**Planning Application No: 3/2025/0607**

**Proposal: Proposed replacement dwelling following demolition of existing house and garage plus extension of the residential curtilage.**

**Location: Glendene Barker Lane Mellor BB2 7EE**

Tahira Akhtar BA (Hons)  
Technician  
Highway Development Control  
Highways & Transport  
Lancashire County Council

SHEET:
EXISTING SITE PLAN

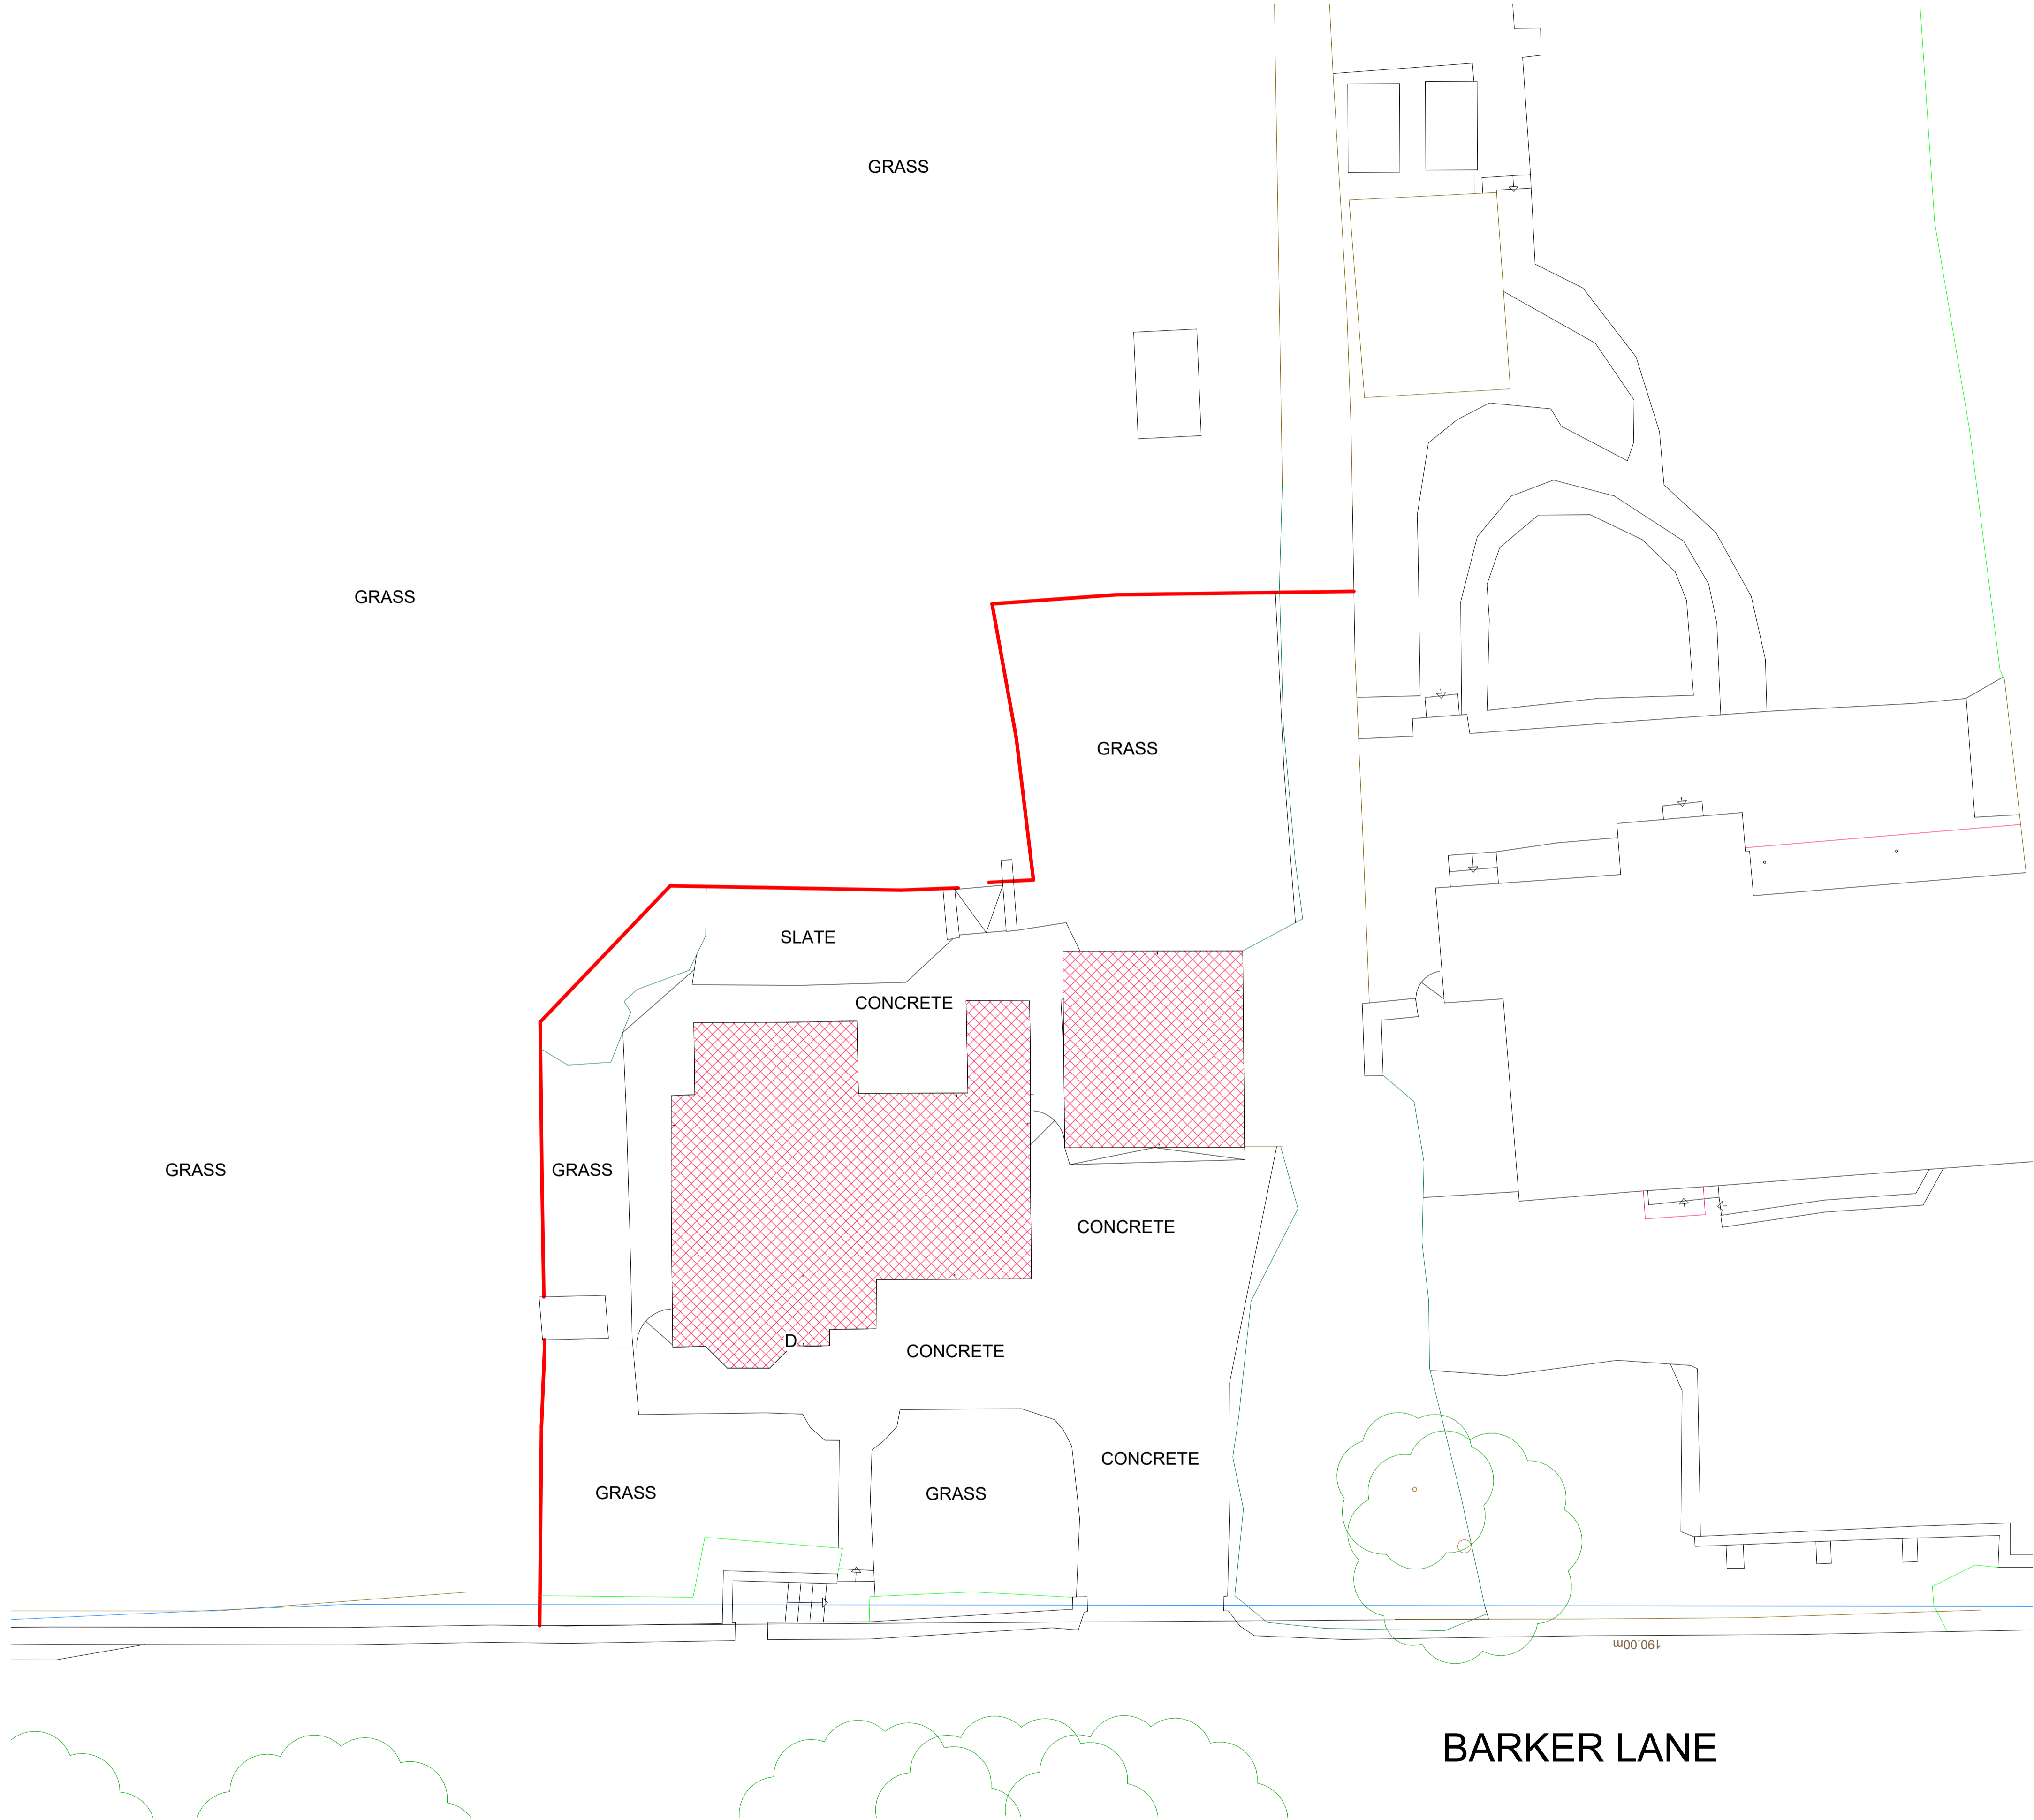
With ref. Planning Statement dated 26.08.25 submitted, there is a loss of a garage. Only 2 parking spaces are being provided. 3 parking spaces are required within the curtilage of the property for this size of dwelling of 4 bedrooms. Please provide a parking plan to show how these can be accommodated.

A secure, covered cycle store is required for 4 bicycles and an electric vehicle charging point. Reason: To promote sustainable forms of transport and aid social inclusion.
